Reference No: 2019/62/91422/E

Site Address: 2, Nelson Street, Birstall, Batley, WF17 9EP

Description: Alterations and erection of rear dormer windows to convert existing building (A2) to 7 apartments (within a Conservation Area)

Officer Report

drawing no 2018-00457- P02 C

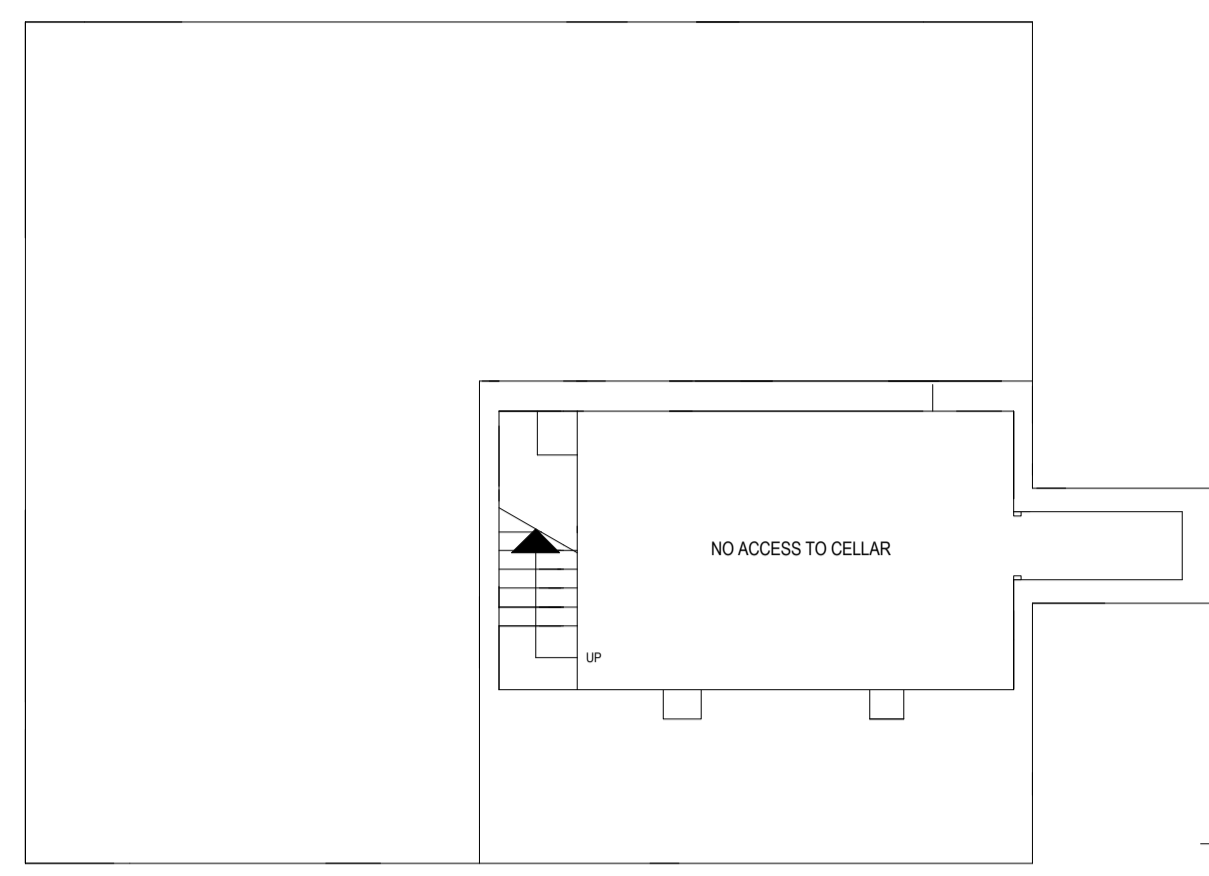
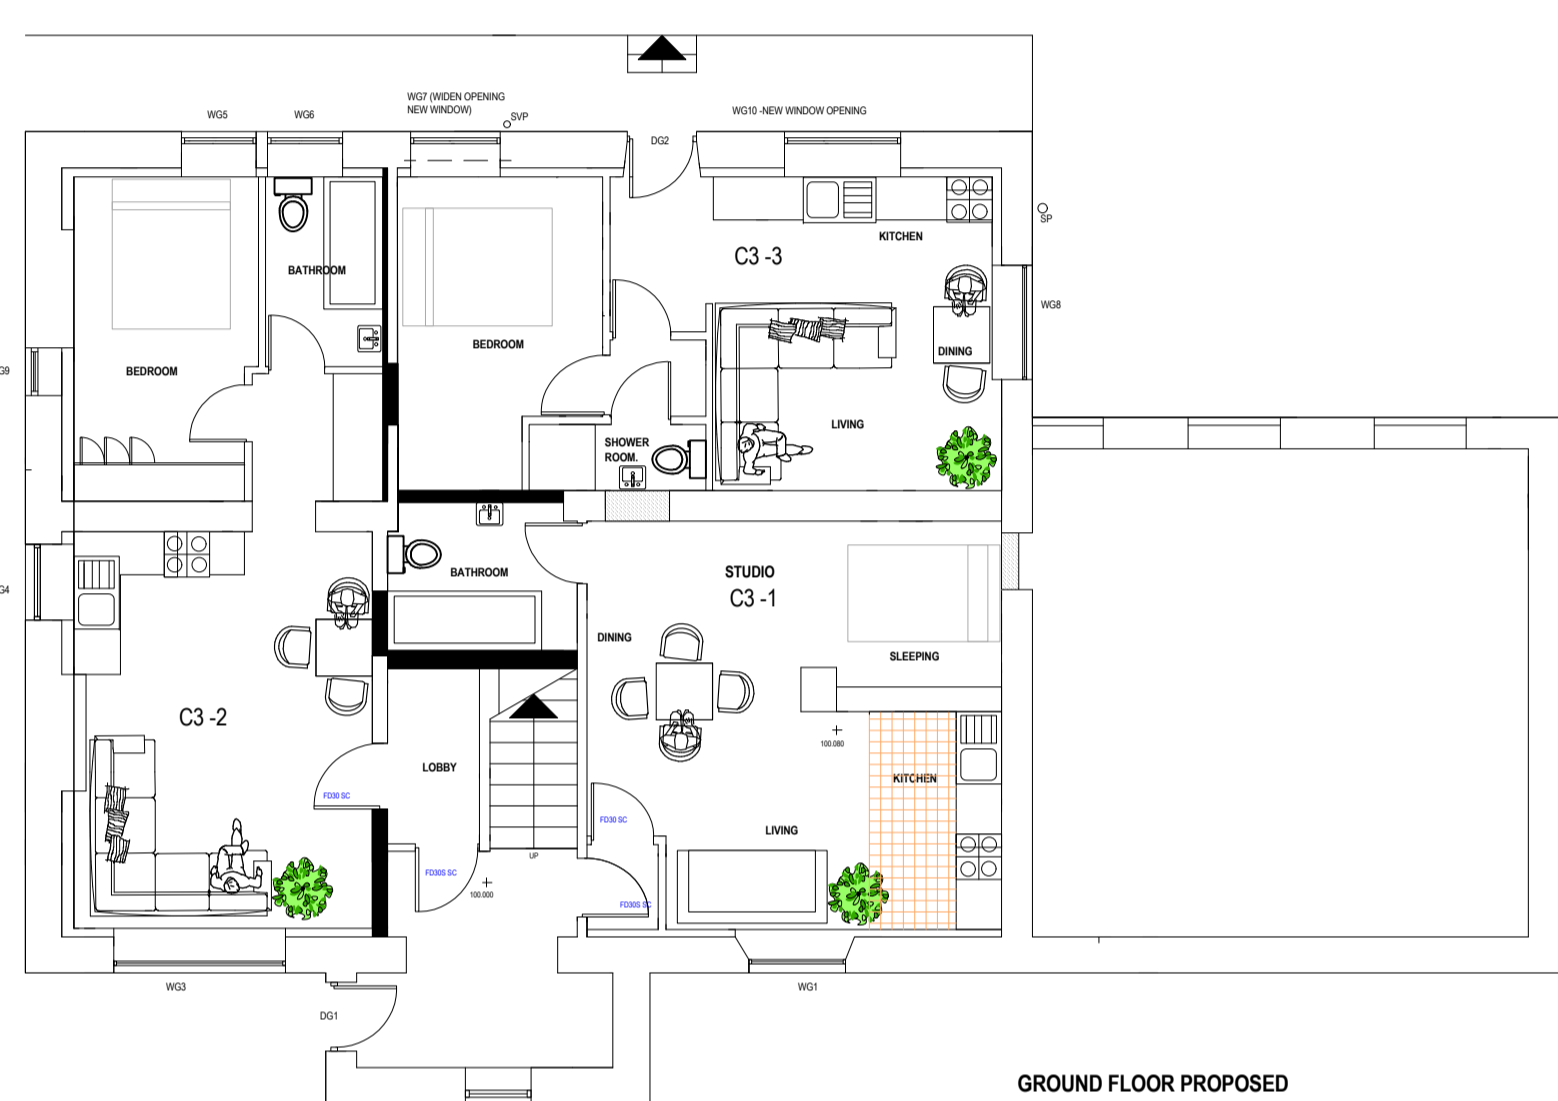
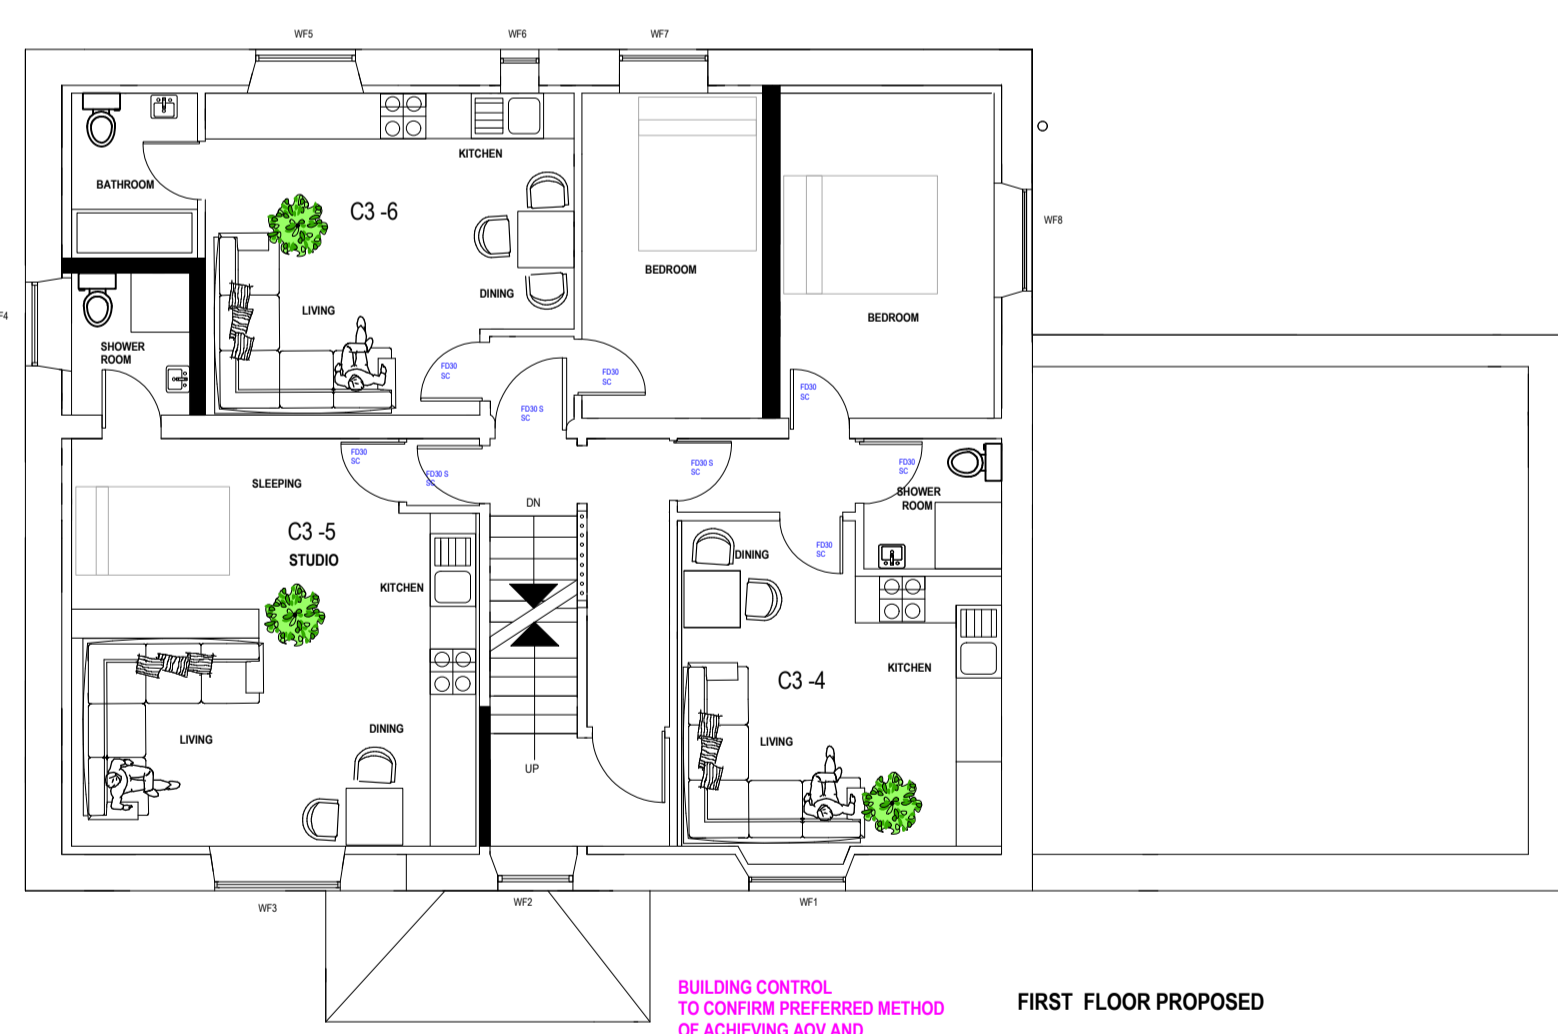
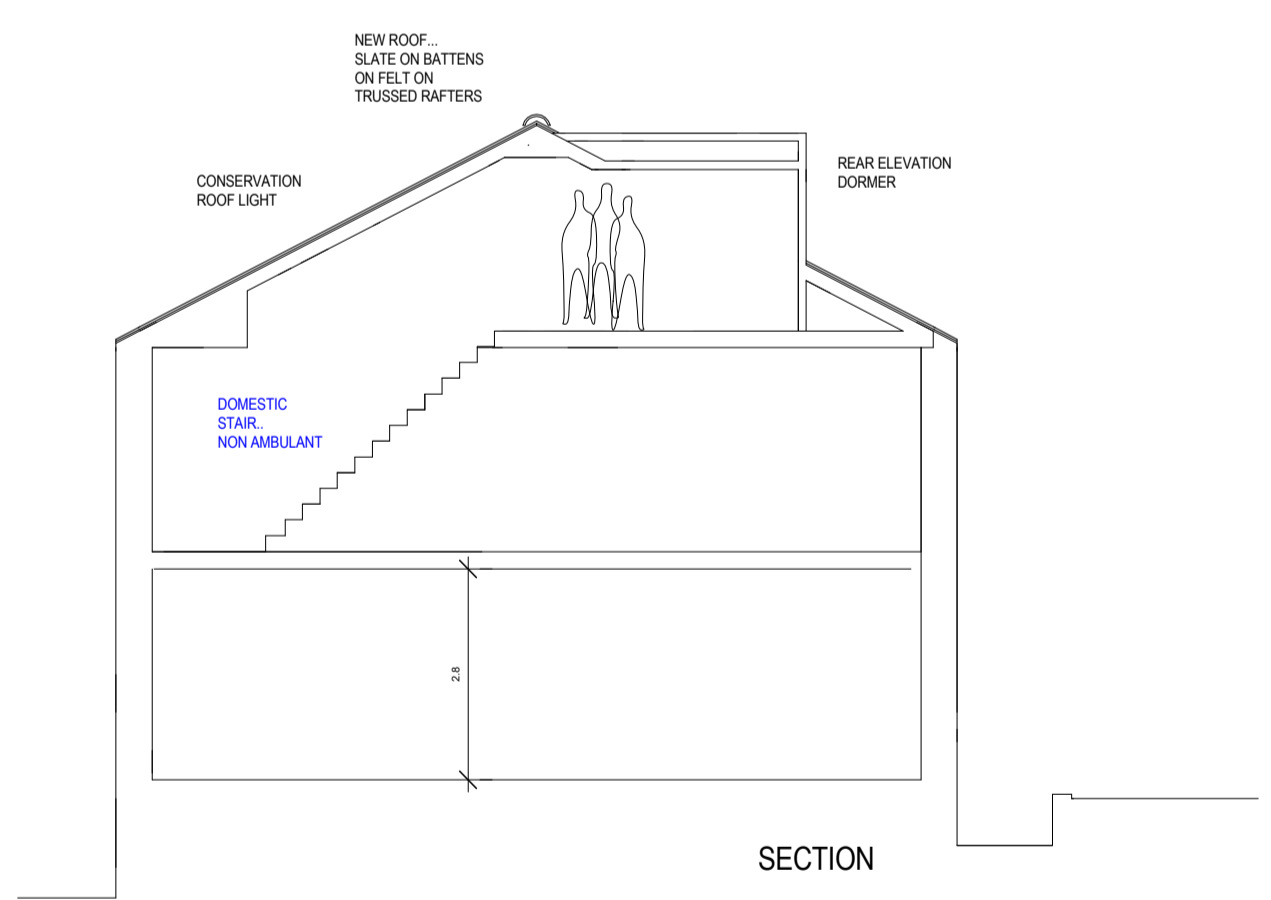
21/06/19. Concerns raised regarding the use of Brazilian stone slate. The two rear dormers should be equally sized.

One of the main alterations to the front elevation of the building would be the replacement of the roof covering. The applicant had originally proposed a dark Brazilian slate, however the existing roof covering is a natural, York stone slate and this would have altered the character of the building. The Conservation and Design officer has objected to this alteration.

The amended plans show the two dormers to the rear would now be of equal size and design and positioned so that they are equidistant from the sides of the building. This is considered appropriate and, due to the position at the rear of the building would not be visible from a public vantage point.

Within the east side elevation of no. 2 Nelson Street, the original proposals were for a kitchen/dining window at ground floor and a bedroom window at first floor level. These would have had a direct relationship with a bedroom window in the side elevation of no. 6 Nelson Street at a distance of around 8.5m.
